**From:** Rich Elliott <elliotttr@kvfr.org>  
**Sent:** Wednesday, May 22, 2013 2:18 PM  
**To:** Jeff Watson; Dan Valoff  
**Cc:** Joe Seemiller; Brenda Larsen; John Sinclair  
**Subject:** RE: Kittitas County Notice of Application AU-13-00003 Lund

**Cc:** Doc Hansen; Rich Elliott; Keli Bender (krd.keli@fairpoint.net); 'lonnie\_allphin@ksd403.org'  
**Subject:** Kittitas County Notice of Application AU-13-00003 Lund

LUND SITE PLAN, 3802 CARIBOU RD

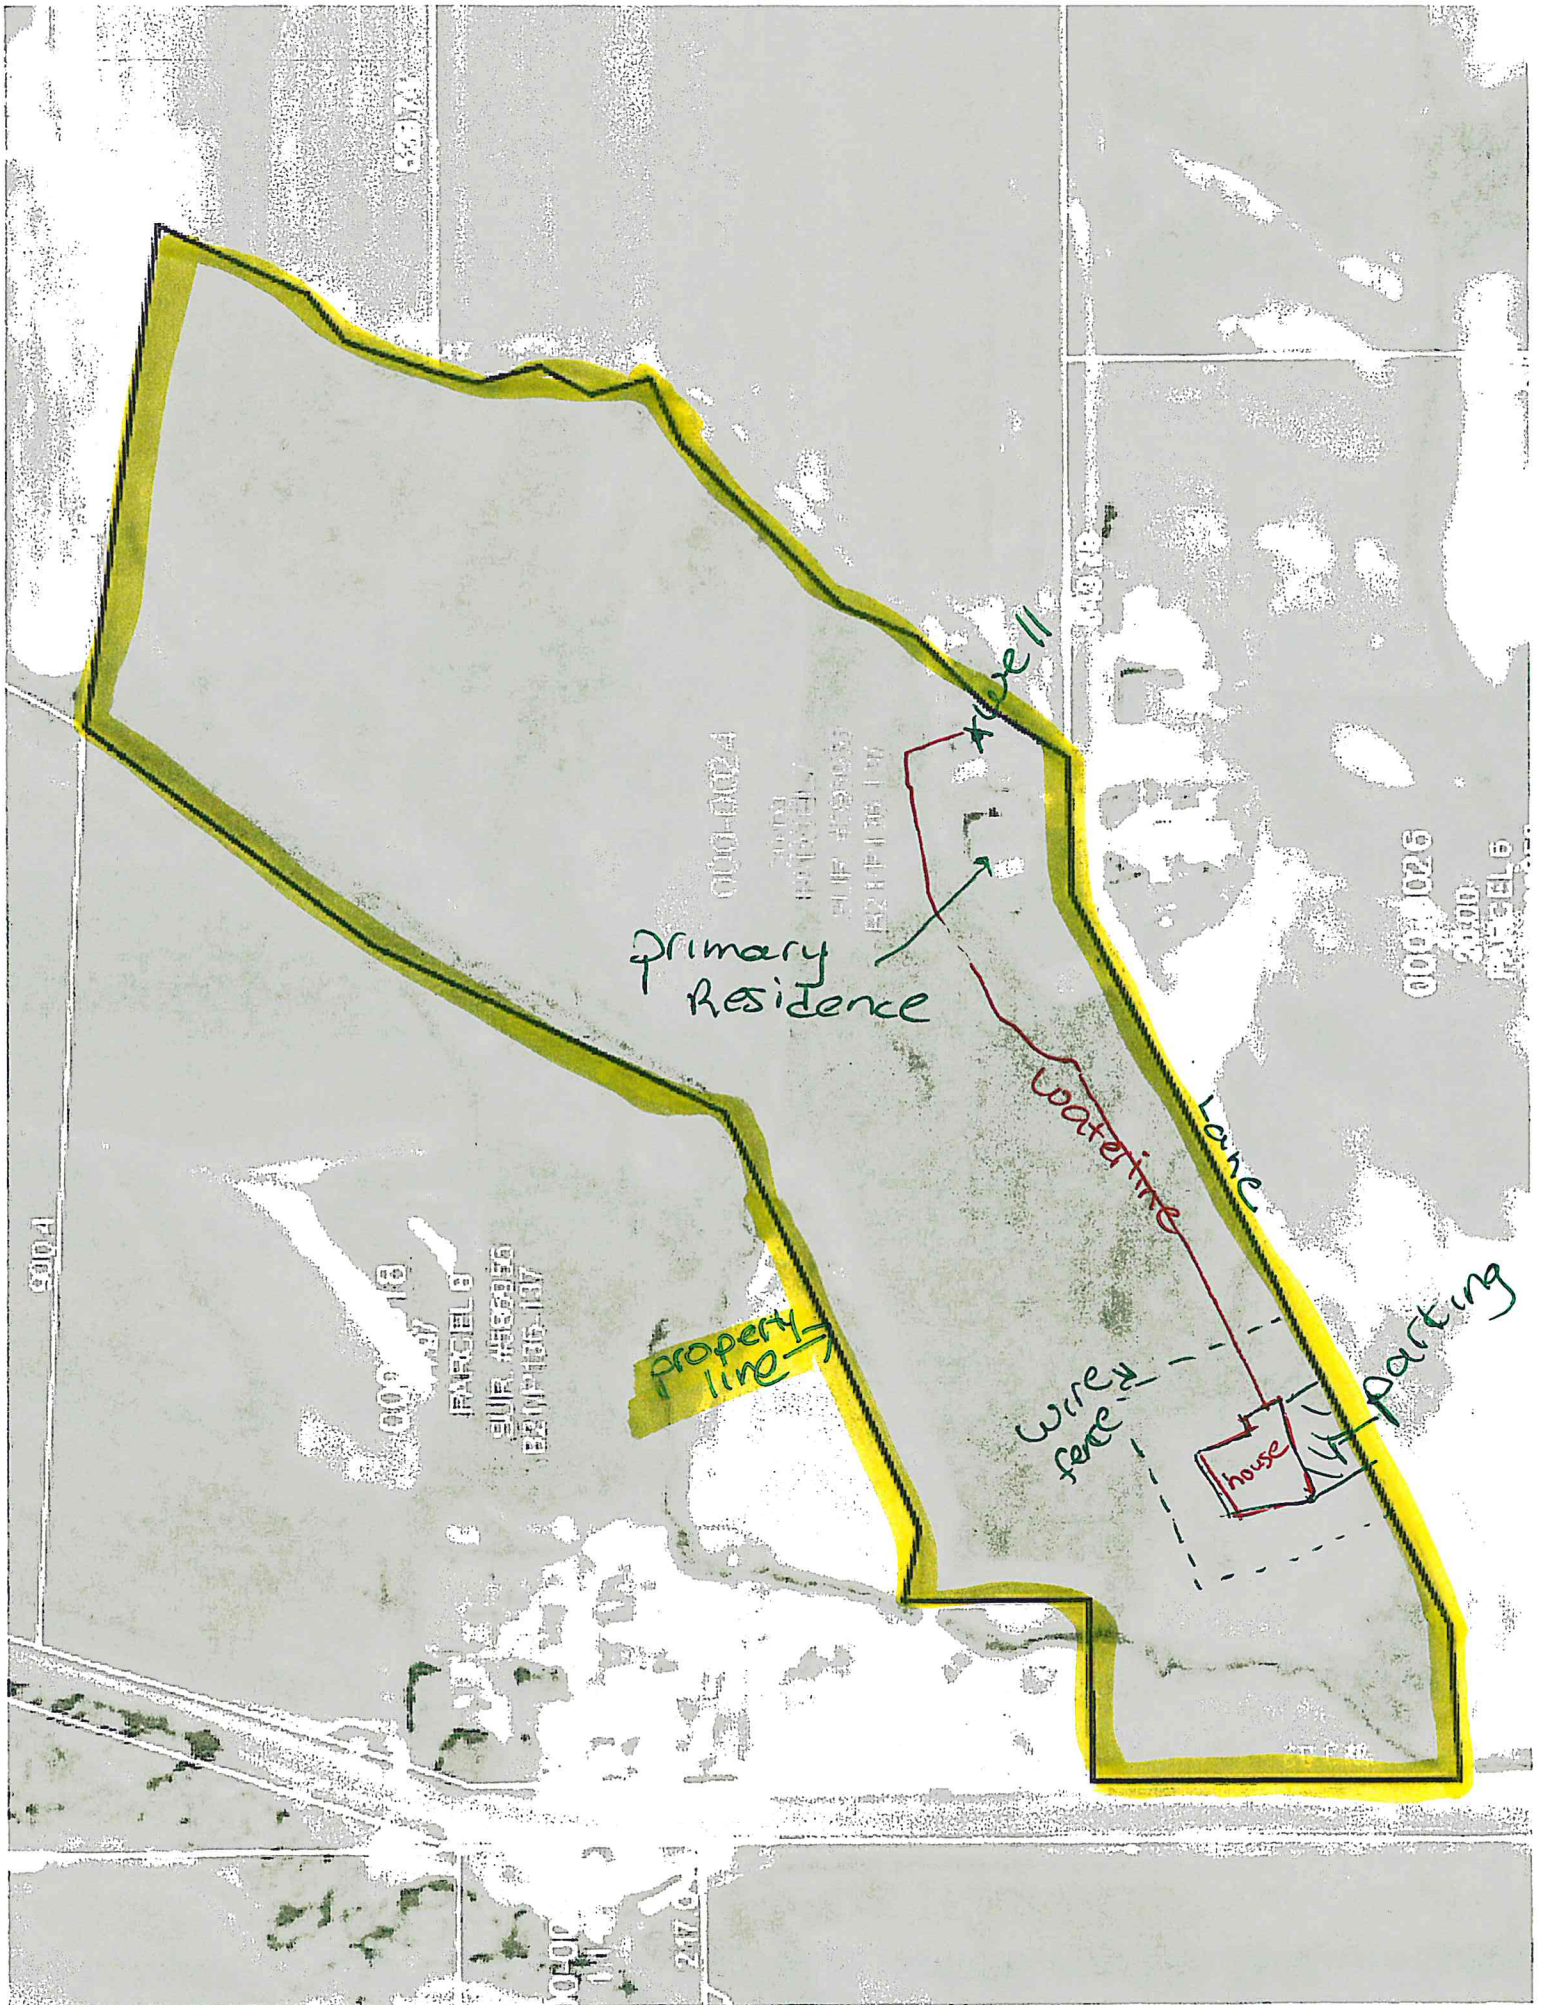
1. The accessory dwelling unit will need to be individually addressed and clearly marked from the public road access as well along any private access roads or driveways.
2. It is strongly suggested that the structure be built to WUI code standards and that the property owner be made aware that response times are estimated to exceed 12 minutes from time of call.
3. Access will need to comply with 2009 IFC – Appendix D.
4. Water supply for suppression may be limited.
